WEST SUSSEX COUNTY COUNCIL CONSULTATION

TO:	Arun District Council FAO: Maria Tomalova
FROM:	WSCC - Highways Authority
DATE:	27 October 2021
LOCATION:	McDonalds, 3 Oldlands Way, Bognor Regis, PO22 9SA
SUBJECT:	BE/151/21/PL Installation of one rapid electric vehicle charging station. This application is in CIL Zone 4 (zero rated) as other development.
DATE OF SITE VISIT:	N/A
RECOMMENDATION:	Advice
S106 CONTRIBUTION TOTAL:	N/A

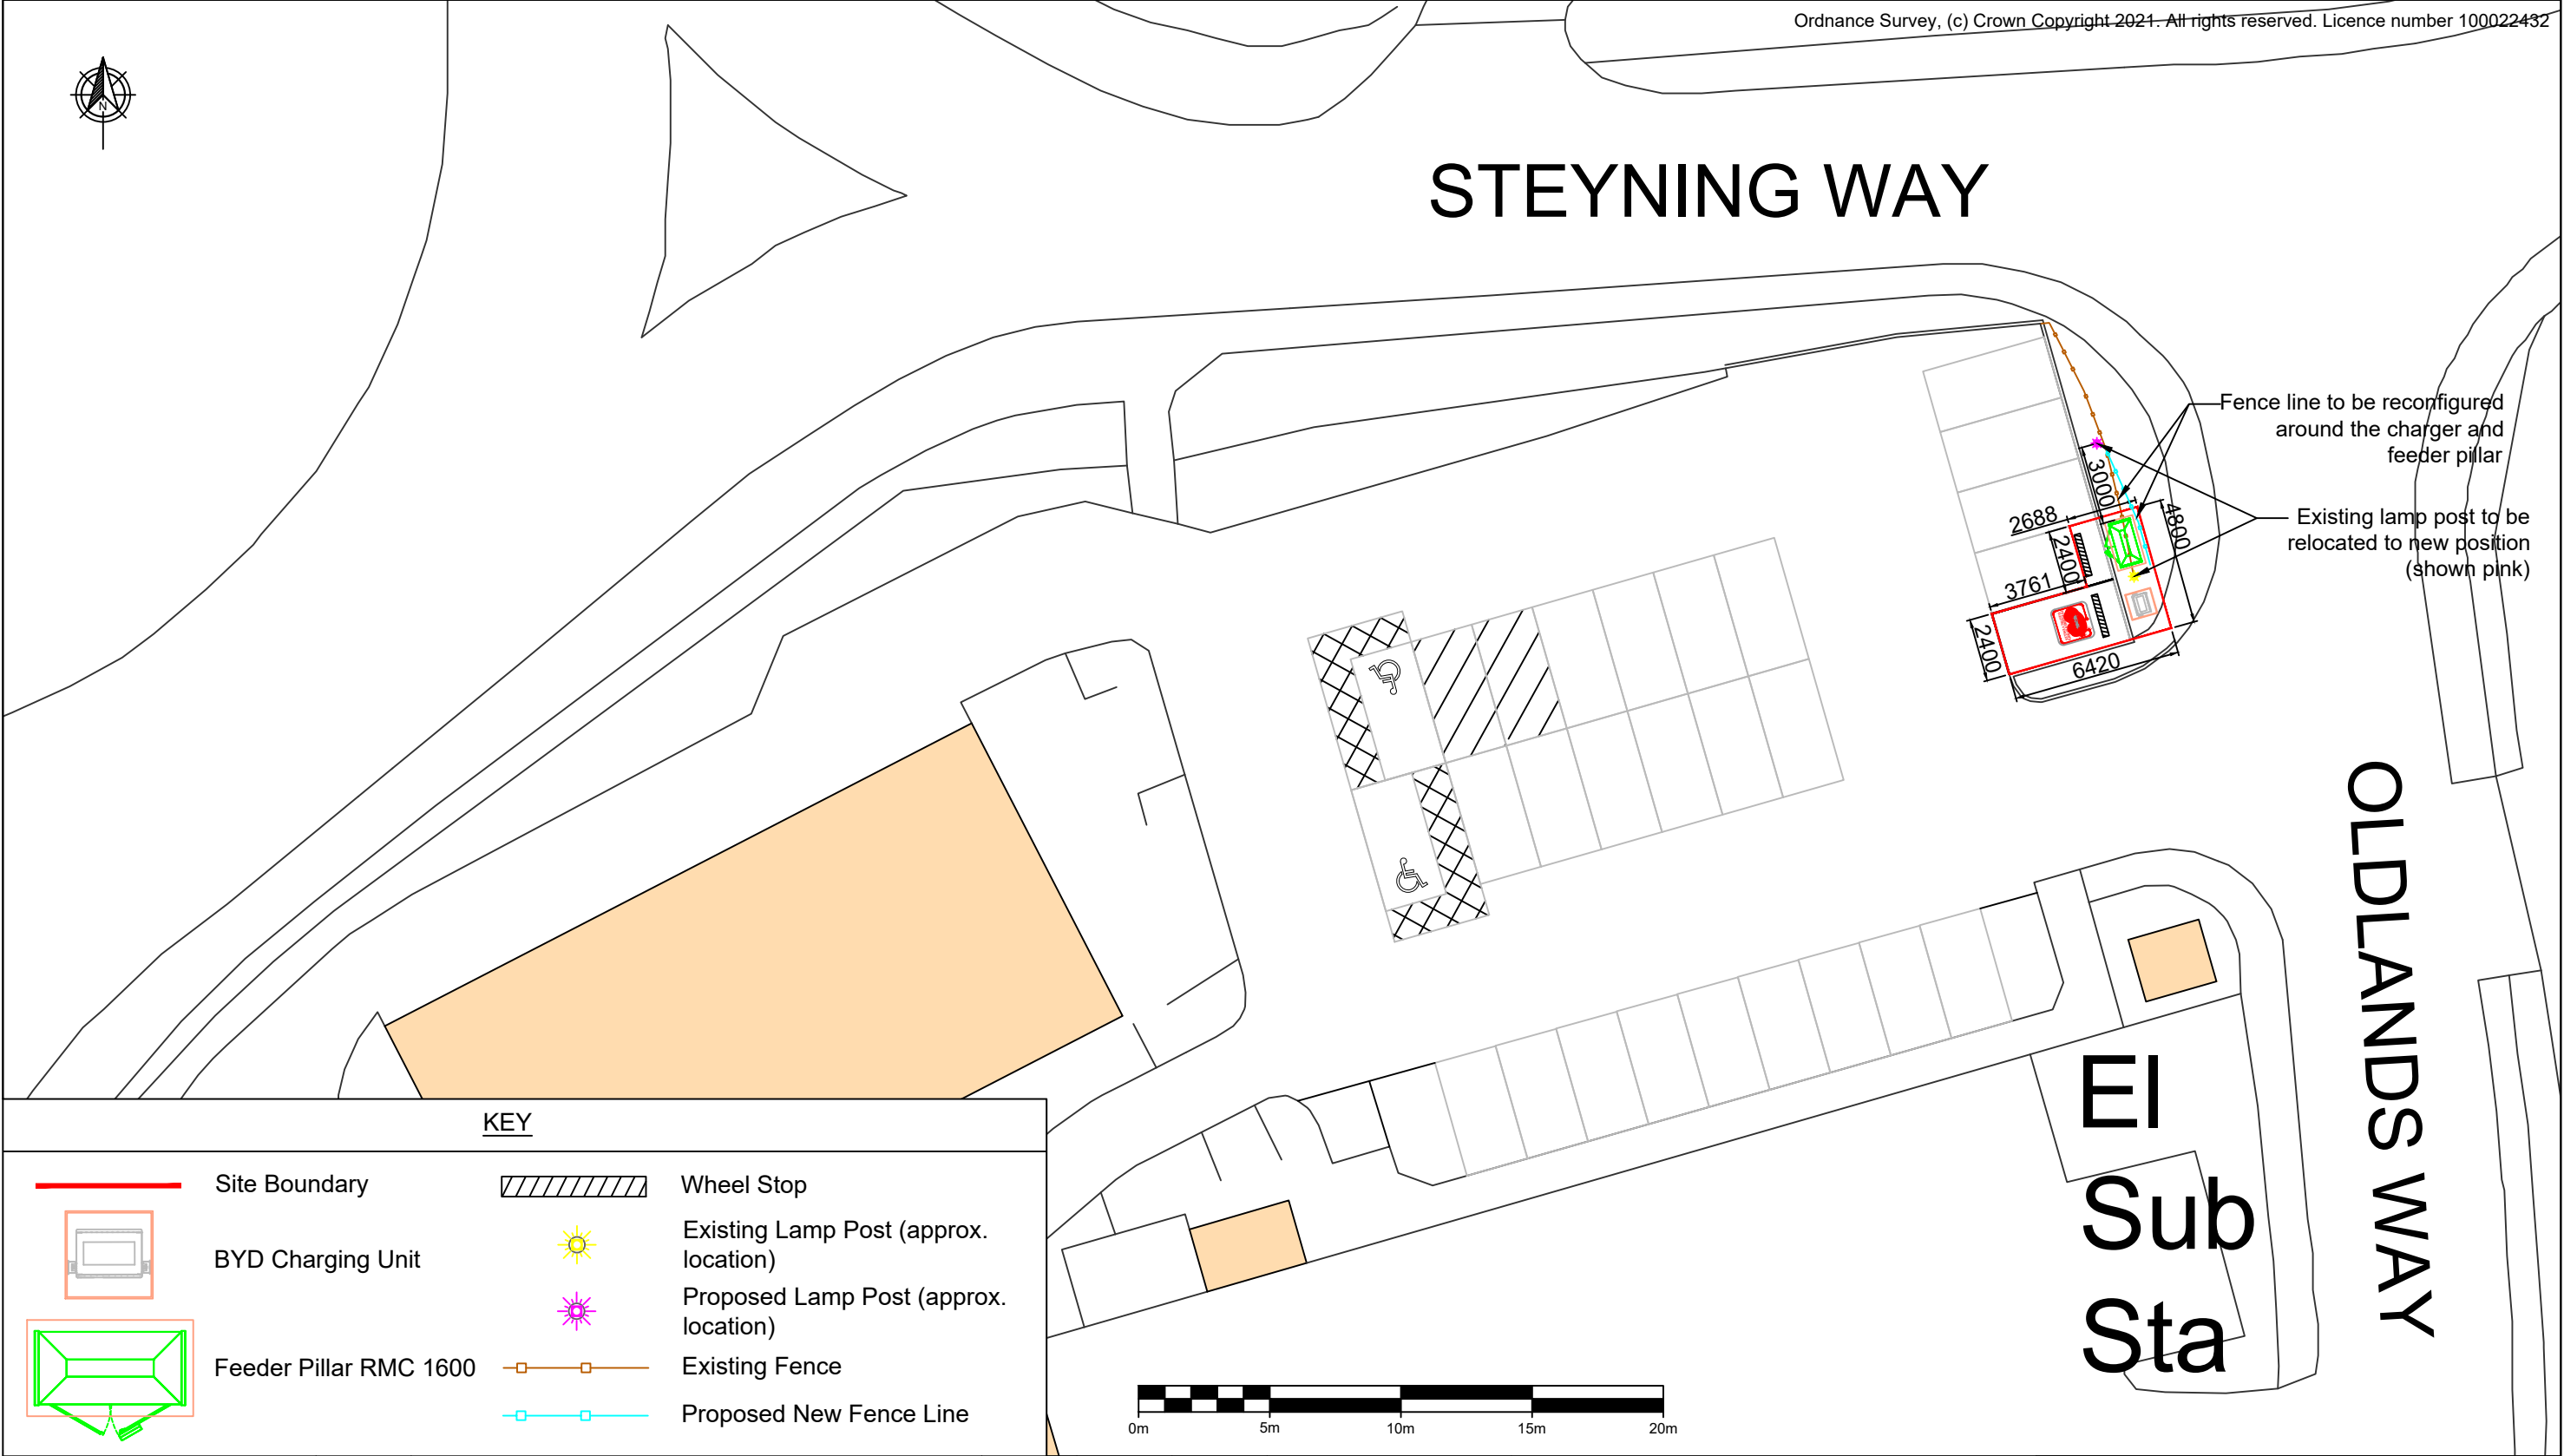
From inspection of the plans, the applicant proposes to convert an existing car parking space to an EV charging space. No alterations are proposed to the existing parking layout.

The proposed charging unit, feeder pillar, relocated lamp post and fence line are to be located within private land and will not encroach into the maintained highway boundary. In addition, the proposed structures are not anticipated to obstruct vehicular visibility for those using the access on Oldlands Way.
